Application No: AB/14/21/HH
Site Address: Riverside House 2 Fitzalan Road Arundel BN18 9JS
Description of works: Reinstatement of timber jetty using existing 3 piles.

Thank you for your internet representation made on 24th March 2021 which has been recorded as an objection with the comments as follows:

Scale: 1:100 @A3	Drawn: A.Stegarescu	Checked: R.Stefanski	Date: Feb 2021
Job No: 1477	Drawing No: PL 102	Revision:

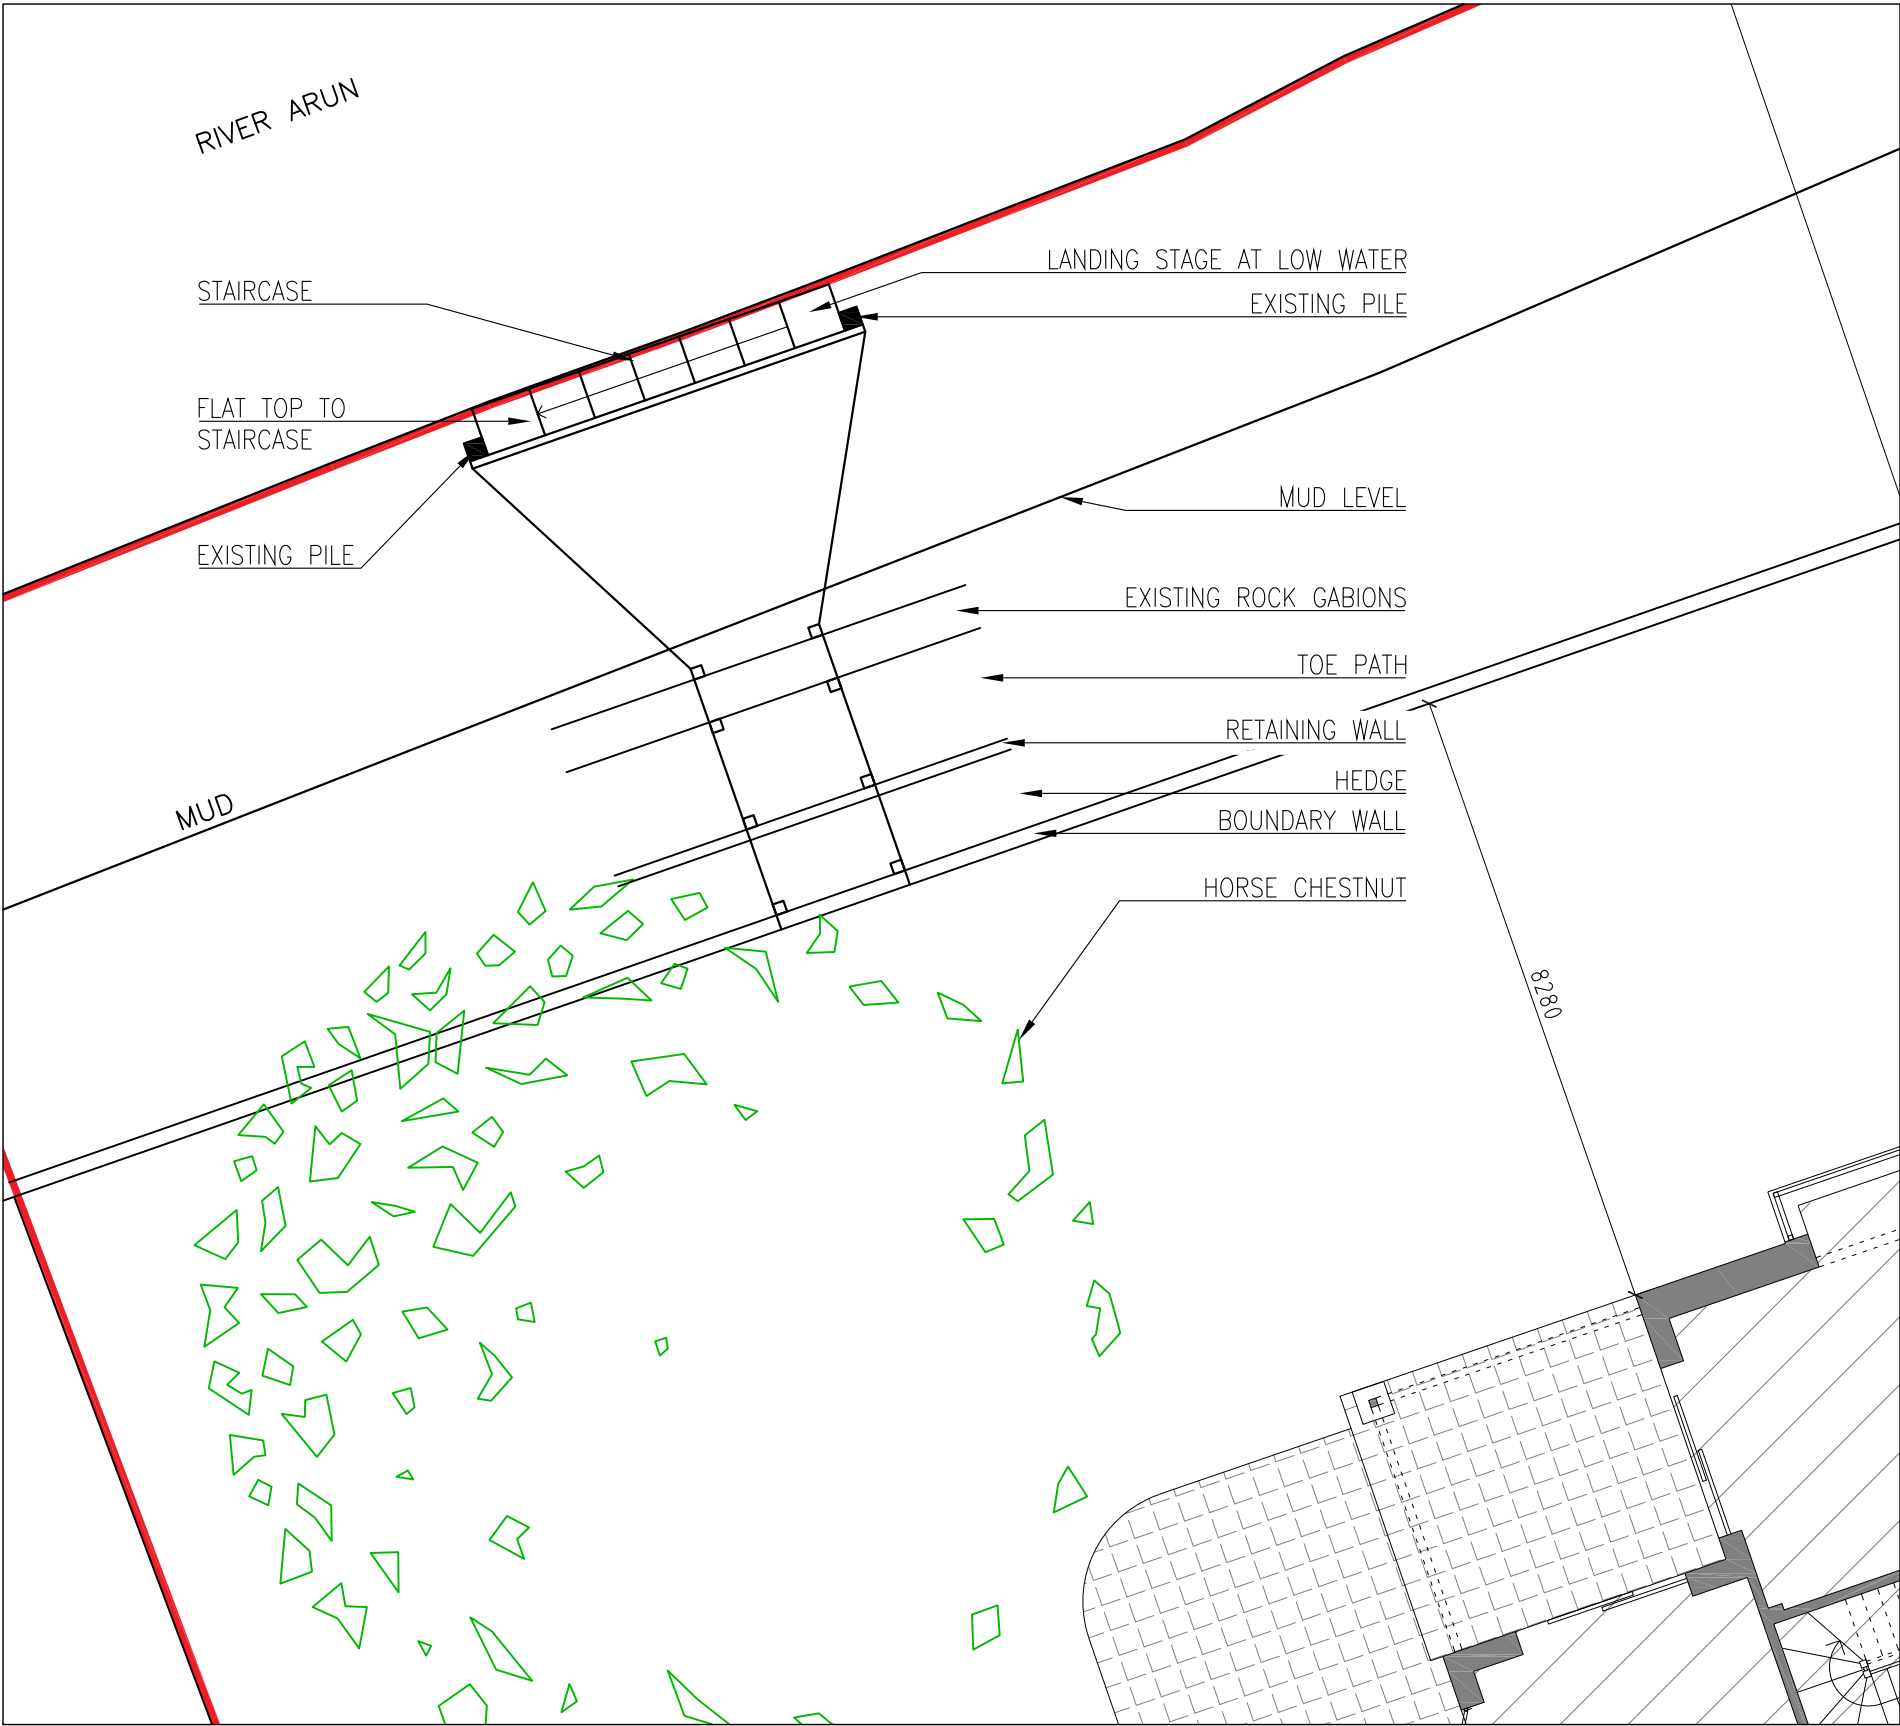
2. The Environment Agency need to have free access along the gabions for the purposes of flood protection and this proposed structure will block that access.

4. The size of the proposed structure will act as a hazard to navigation, narrowing the river exactly at a point where many watercraft turn around. Historically, the three posts described in these plans have previously been used as a turning posts for vessels needing to go back down river after unloading at the wharf.

5. Currently the properties at Otmers Quay have a thick hedge, planted with thorny plants, specifically to act as a security barrier to any entrance from the tow path. The proposed bridge over the top of the hedge would permit easy access into the gardens of Riverside House and by that route, easy access into the properties at Otmers Quay, breaching that security barrier.

Scale: 1:100 @A3	Drawn: A.Stegarescu	Checked: R.Stefanski	Date: Feb 2021
Job No: 1477	Drawing No: PL 105	Revision:

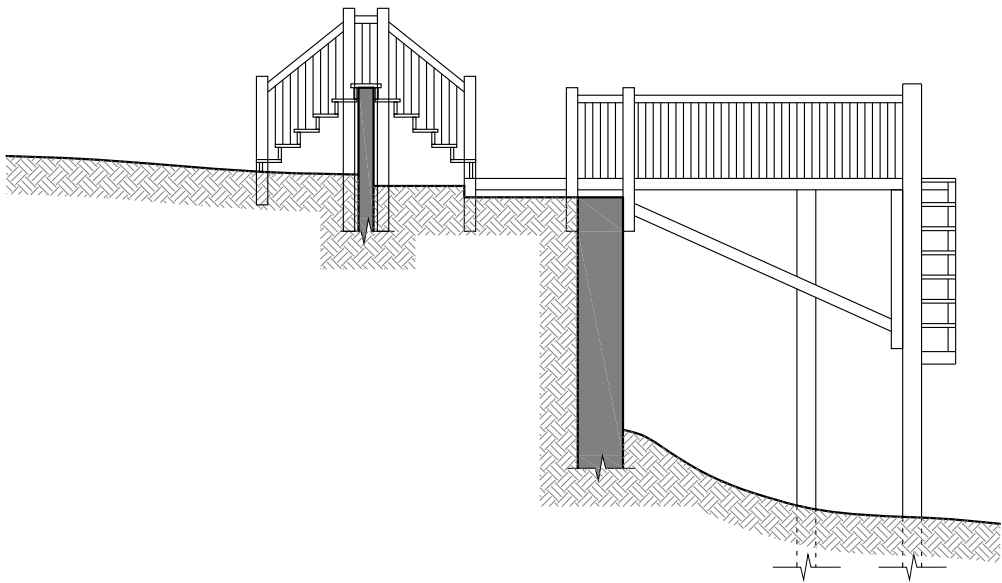
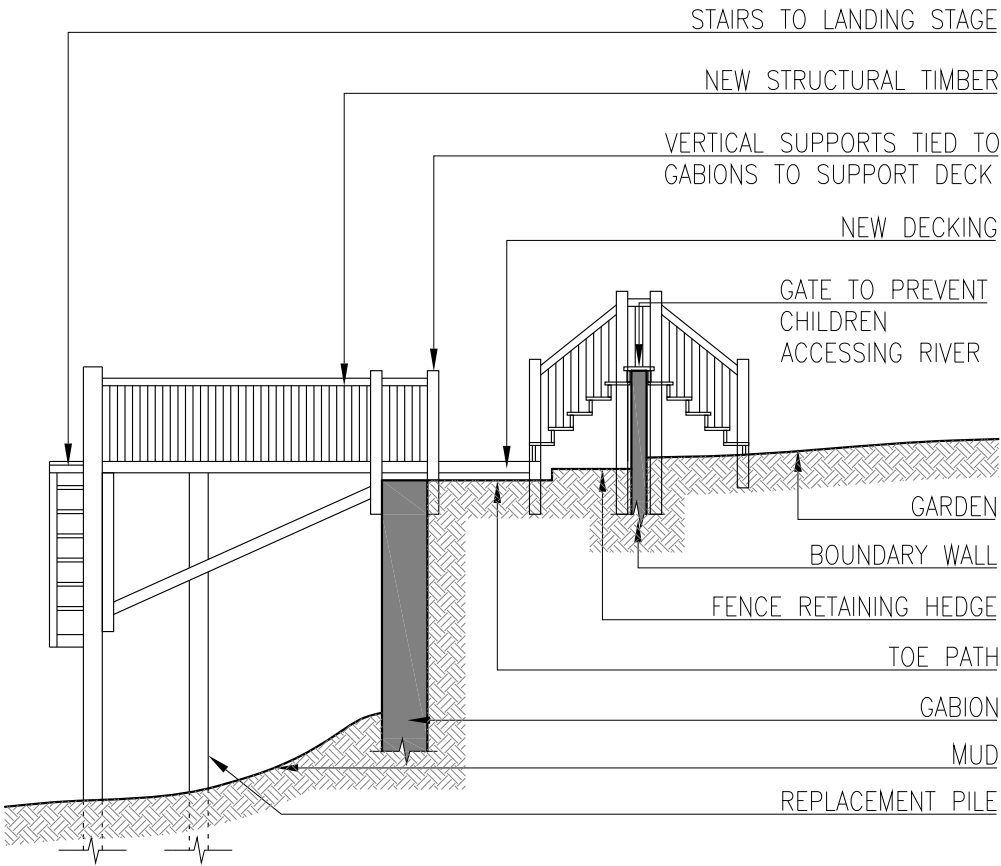
1. The plans are not accurately drawn. In particular PL105 and PI 107 misrepresent the elevations of the site. There is a substantial height difference between the tow path running along the gabions and the garden at Riverside House, which is not shown by the plans.

6. The plans do not appear to include the heights of the proposed structure, but the wooden structure on top of the existing wall, the wooden fencing and the expanse of 'new timber' as marked on the plans, would act as a significant obstruction to views down the river to the town bridge.
